**Consultation Response from KC,
Highways Development Management**

2024/93359 Brayside, 71, Coach Road, Cowcliffe, Huddersfield, HD2 2NW

Demolition of existing dwelling and garage and erection of detached dwelling with detached garage

Date Responded: 23-1-2025

site plan 1-200

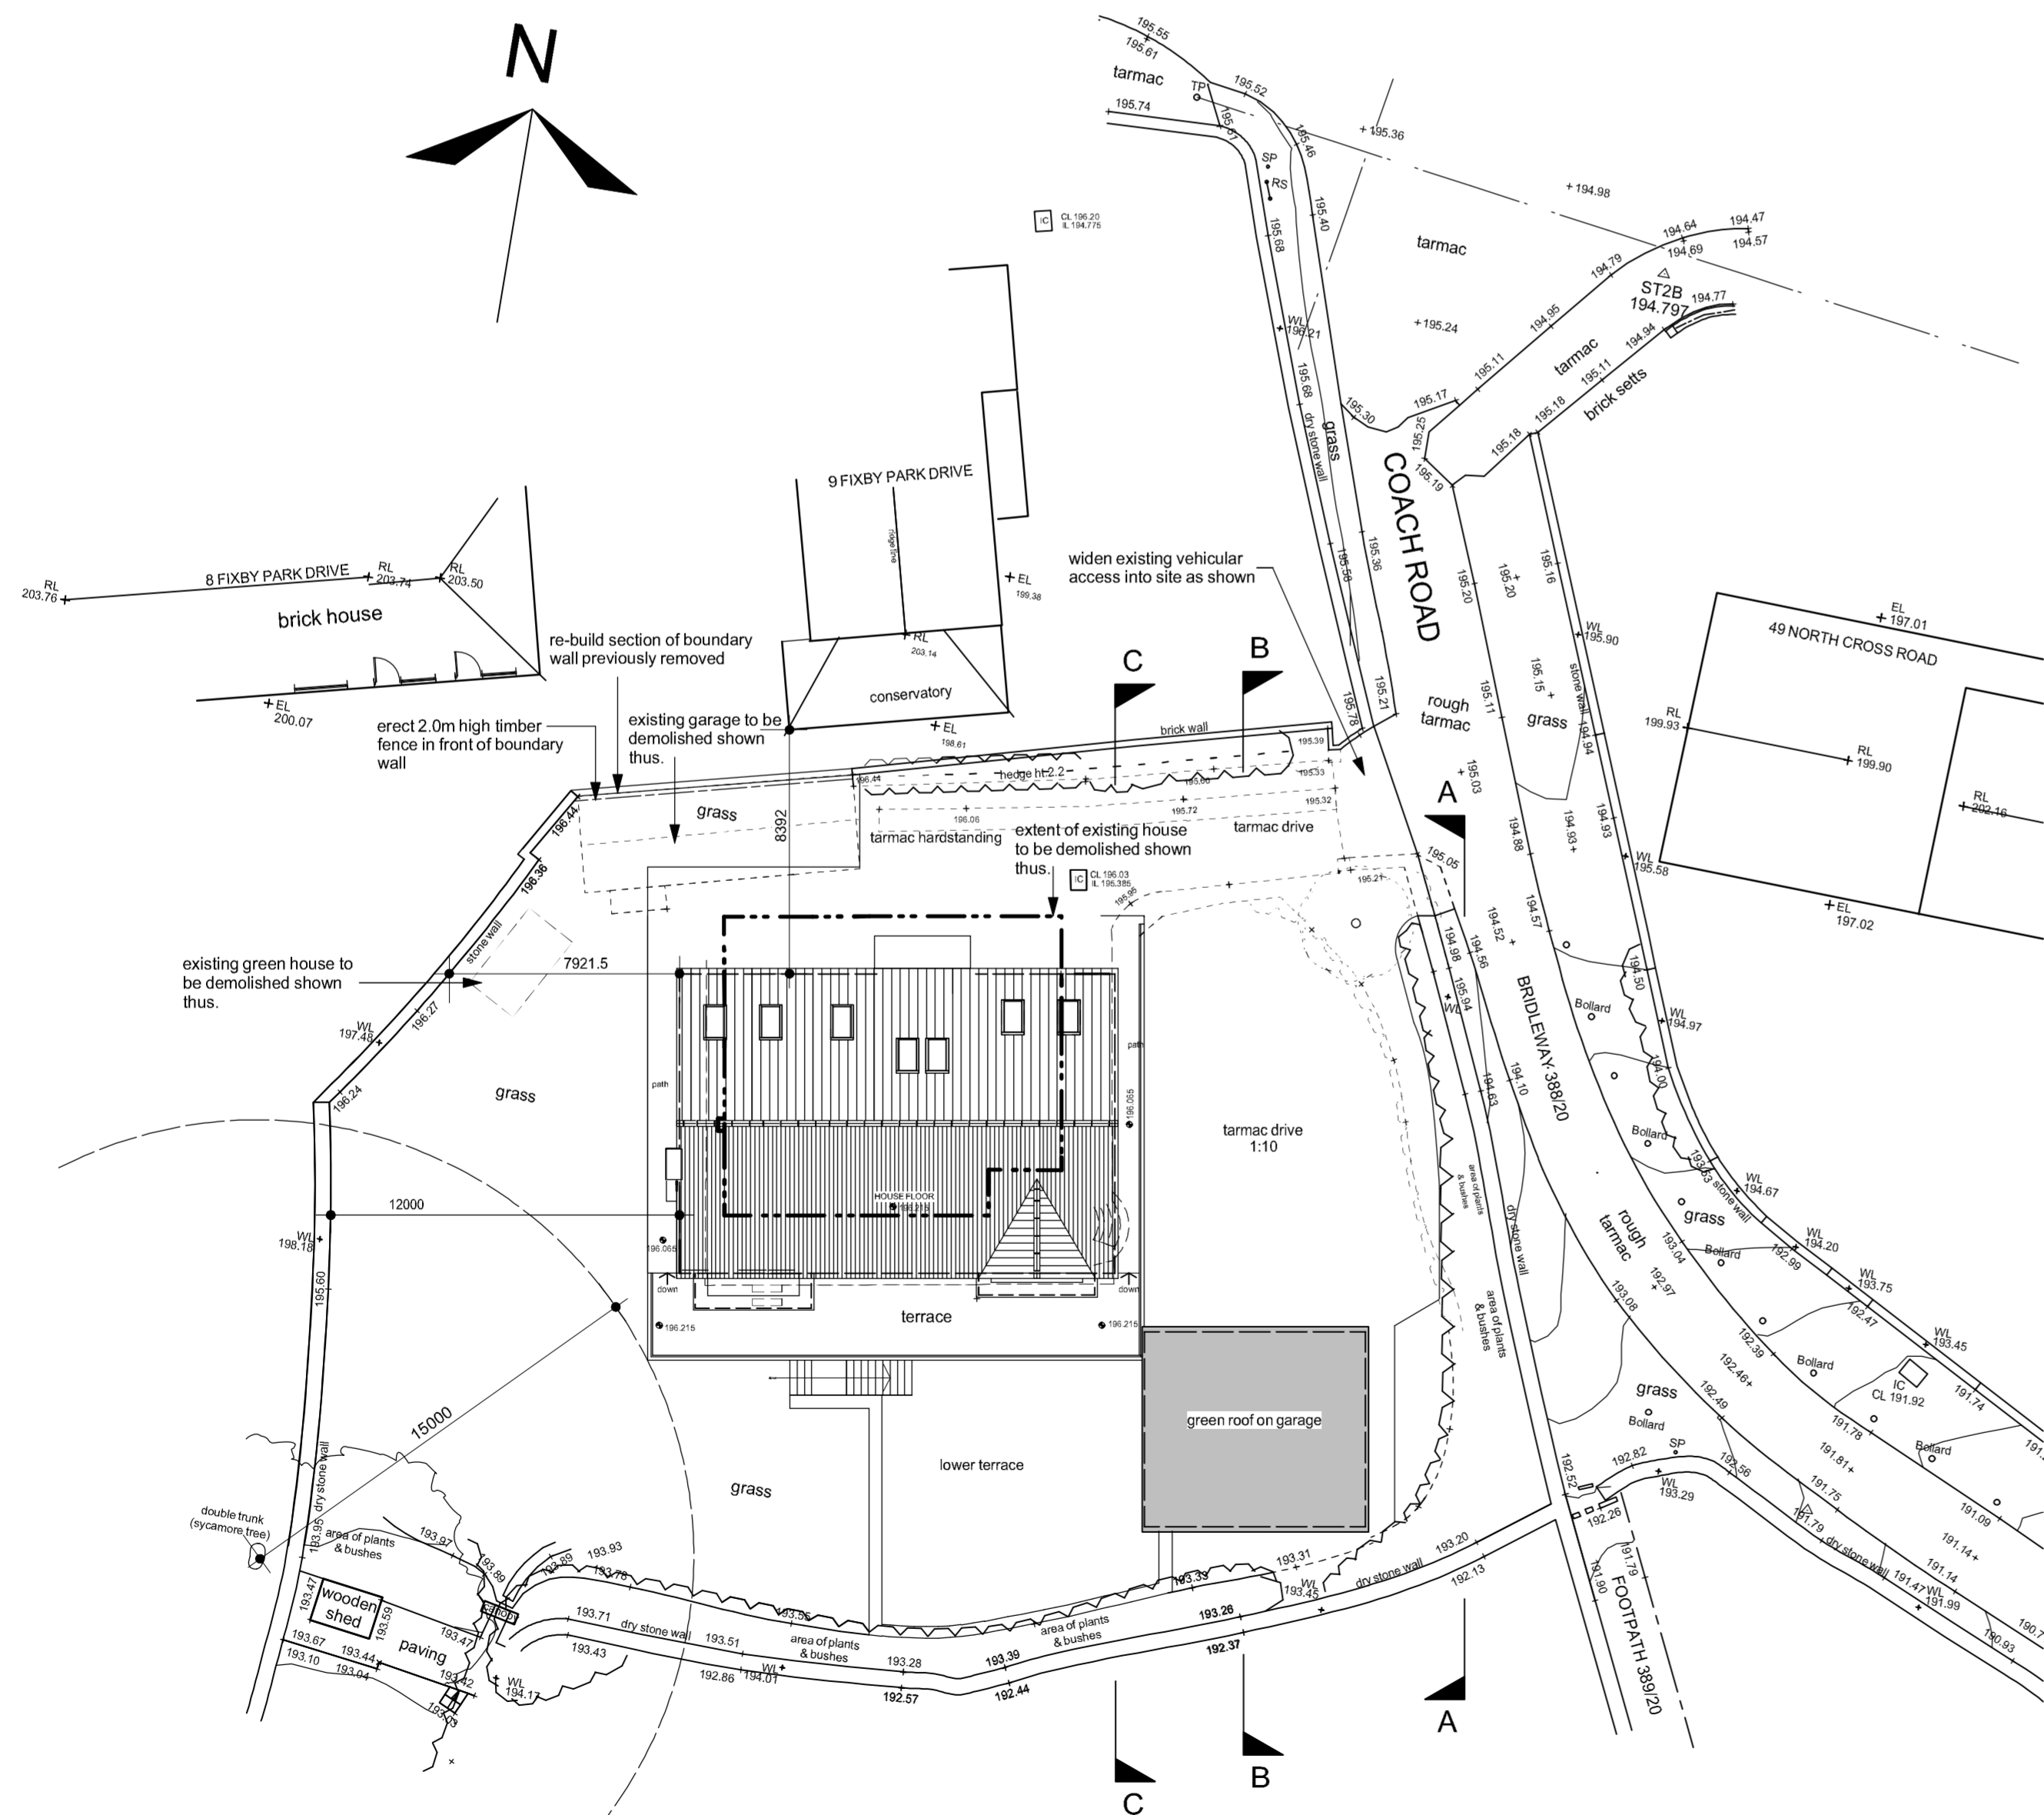
These proposals utilise an existing access onto Coach Road and provide a new 3 vehicle detached garage to the side of the property.

The existing driveway is shown to be widened and the tarmac driveway to the front of the proposed garage provides ample space for parking and internal vehicle turning.

Given that these proposals provide ample off-street parking and internal vehicle turning Highways Development Management have no objection to these proposals.
